Rosefield Solar Farm: consultation on a proposed change to a Development Consent Order application

As a result, we are seeking to make a formal change to the Application to include a bridleway link (‘the Proposed Change’), which would be accessible to the public during the operation (including maintenance) phase of the Proposed Development.

TITLE:
FIGURE 3.10C
EXISTING AND PROPOSED PUBLIC RIGHTS OF WAY
AND PERMISSIVE FOOTPATHS - PARCEL 2

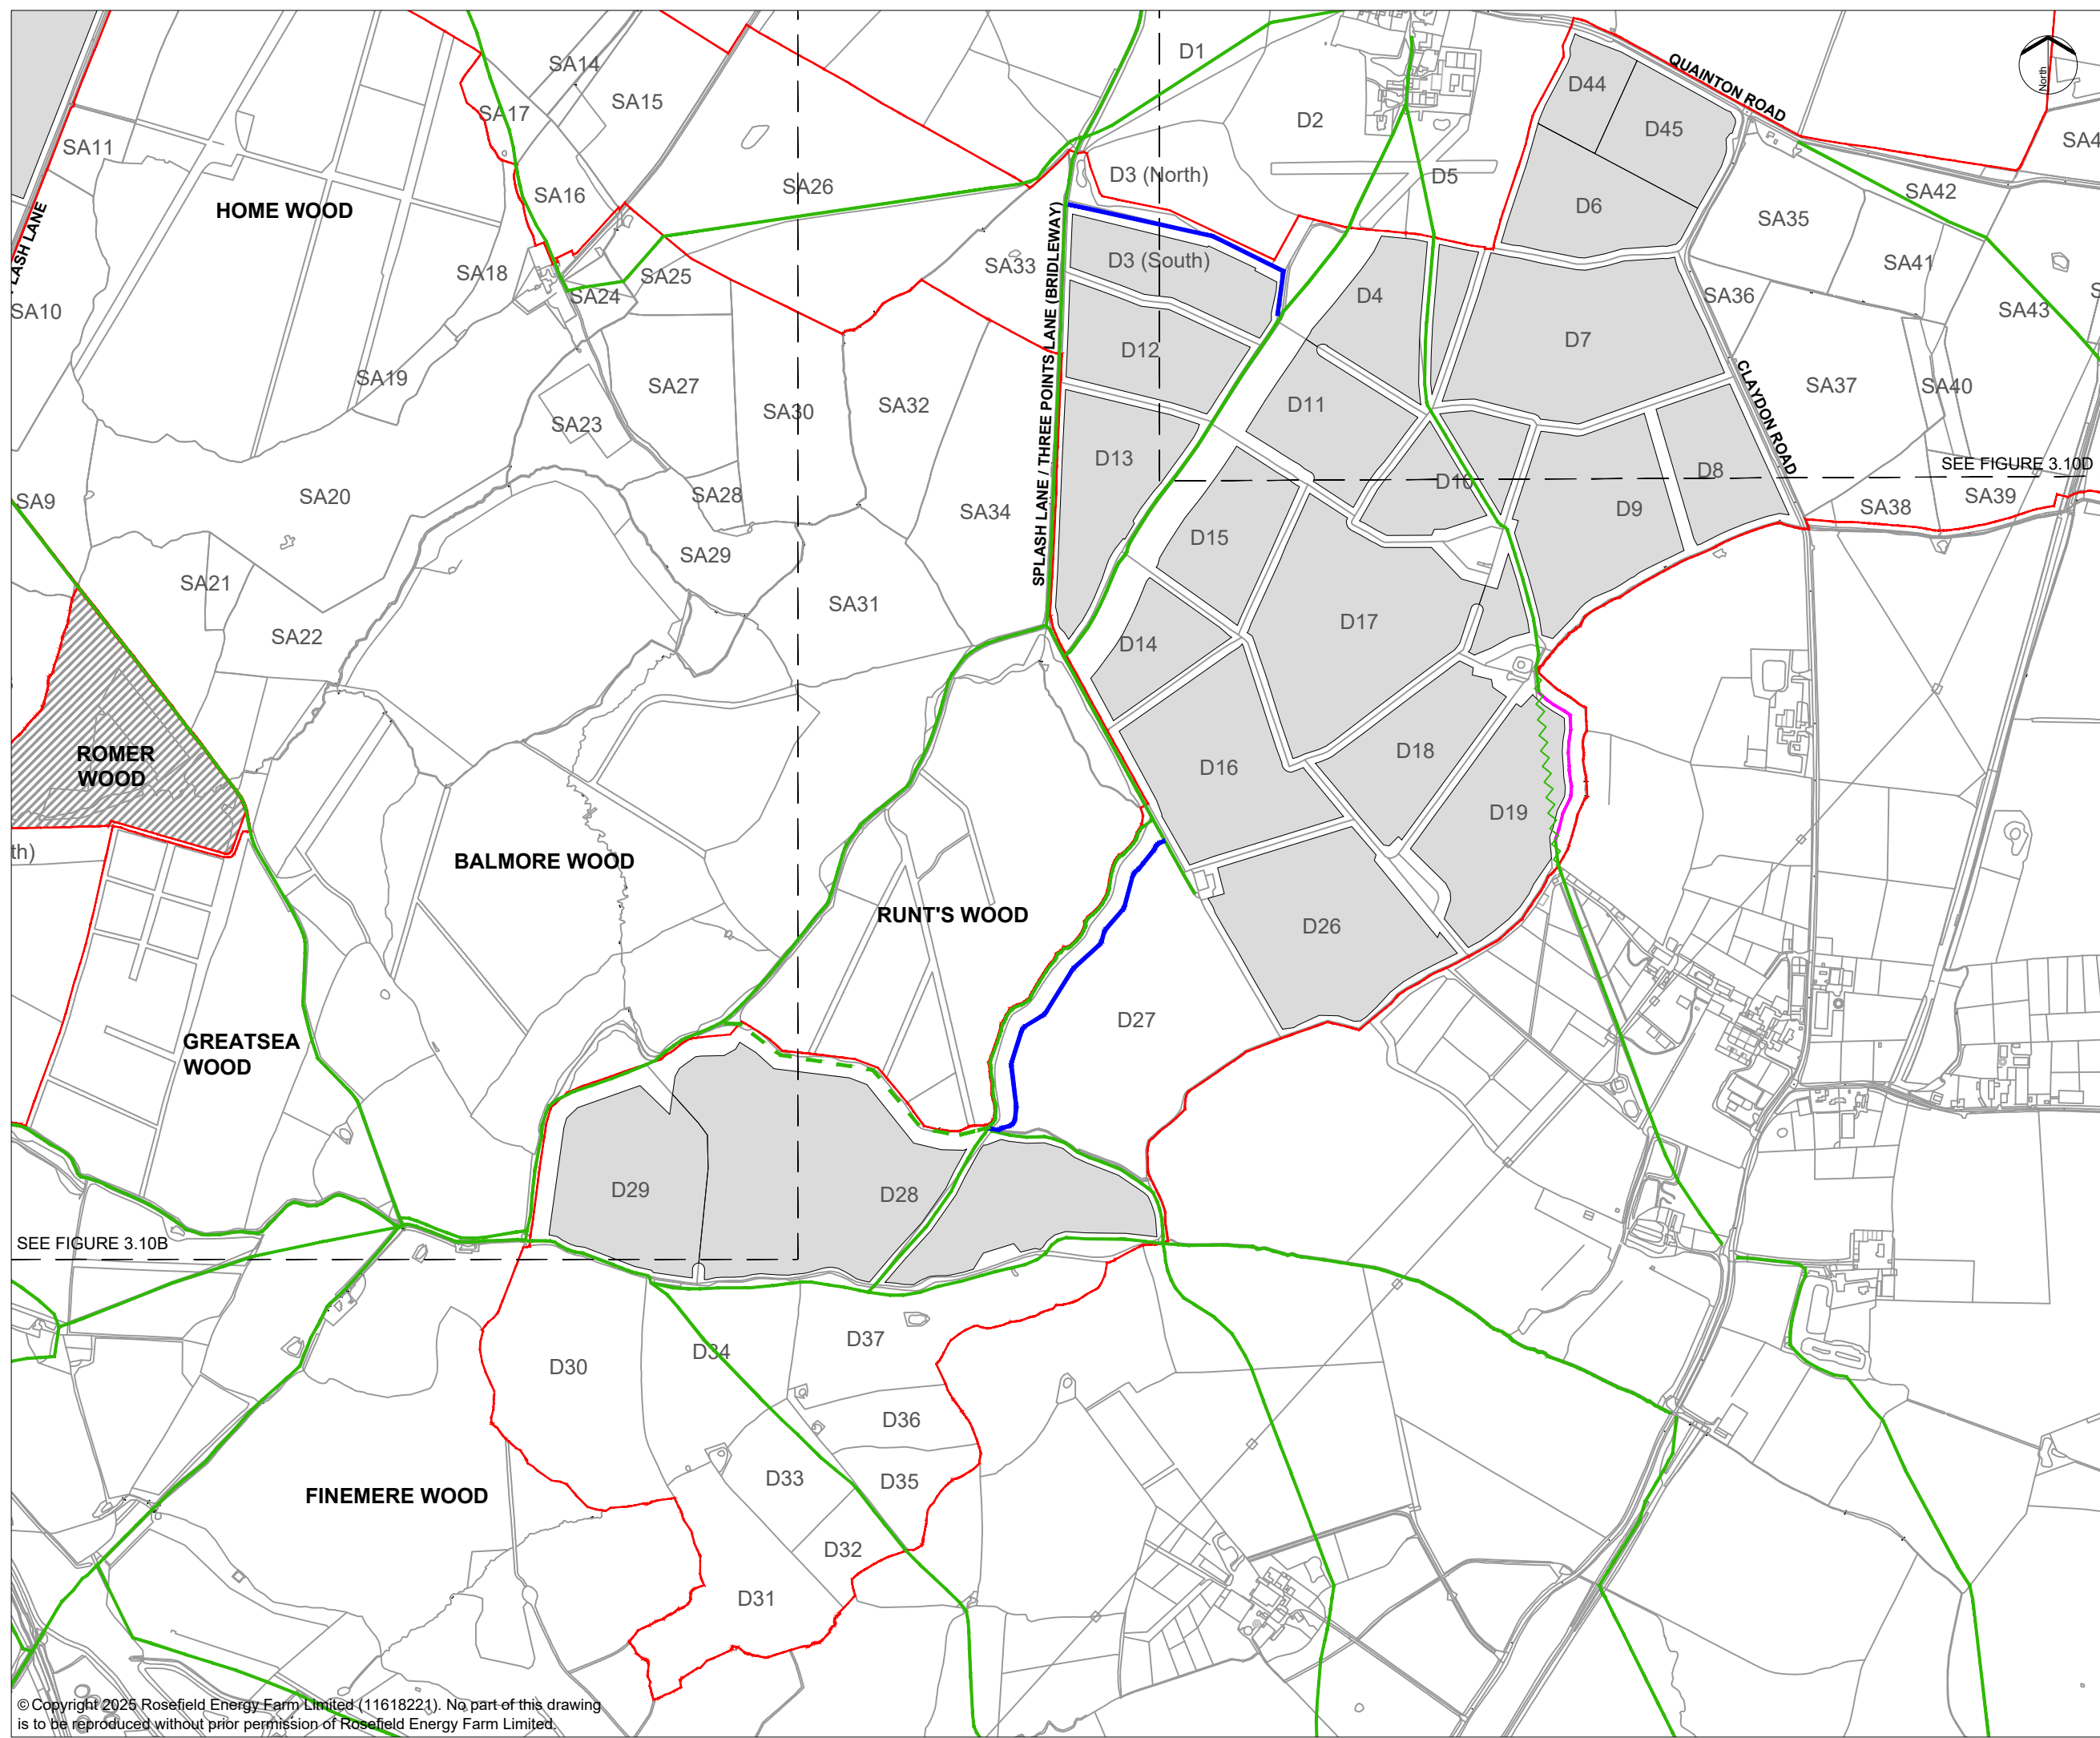
Enclosed is a plan which shows the proposed location of the bridleway link, which is located entirely within the Order Limits. The bridleway link would connect the existing dead-end bridleway ECL/10/5 to the north of Field D27 to bridleway QUA/40/2 and QUA/40/3 which runs along the southern edge of Fields D28 and D29.

The total length of the bridleway link would be approximately 0.9 km long, and would follow the proposed internal access track through Field D27 and then PRow Footpath (reference ‘QUA/41/1’) through Field D28.
